**Consultation Response from KC,
Highways Development Management**

2024/90223 Netherfield Mills, Calder Road, Ravensthorpe, Dewsbury, WF13 3JS

Change of use from car recycling workshop to skip hire and waste transfer station

Date Responded: 29-4-2024.

DRG:  
PROPOSED SITE PLAN

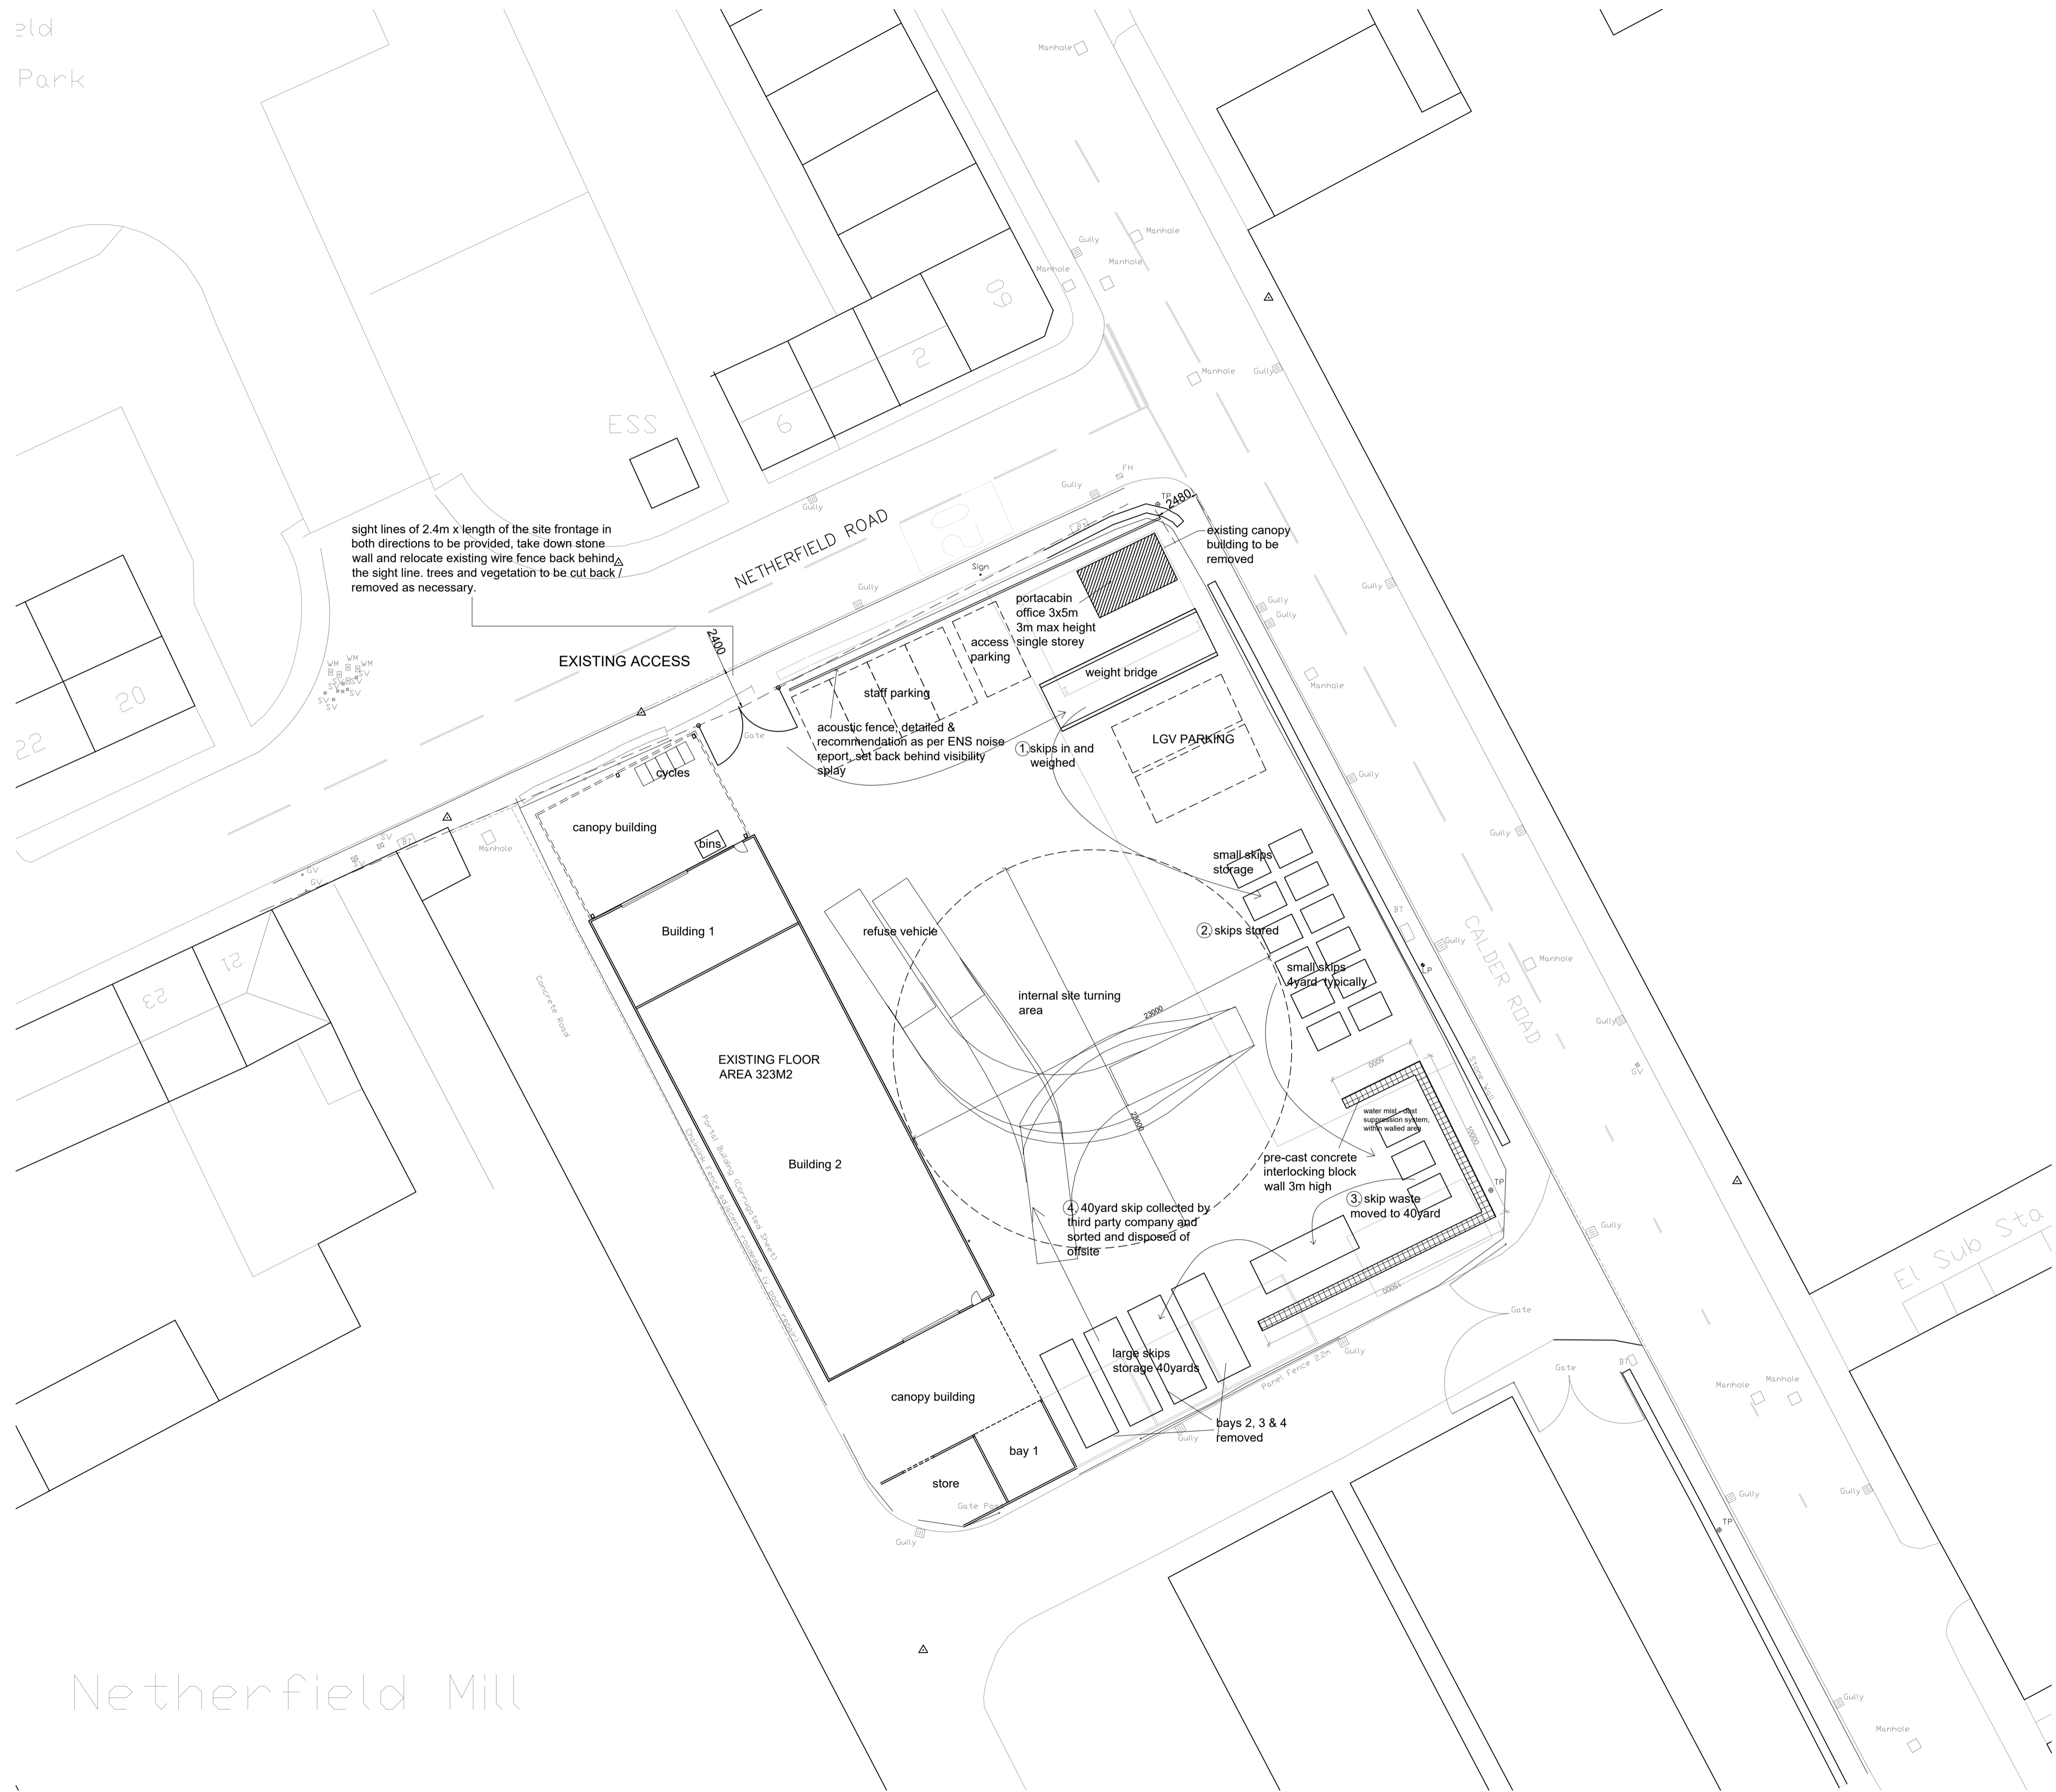
The Proposed Site Plan shows the existing access to Calder Road retained as existing with 4 staff parking spaces, 2 LGV parking spaces, 5 cycle spaces and an internal HGV turning circle.

This application provides insufficient information to allow a proper highway assessment.

1, Details of the anticipated traffic generation and the number of skip hire vehicles that will operate from this site.

2, Vehicle swept paths to demonstrate that the largest vehicle anticipated to regularly access the site can enter, exit and turn within the site.
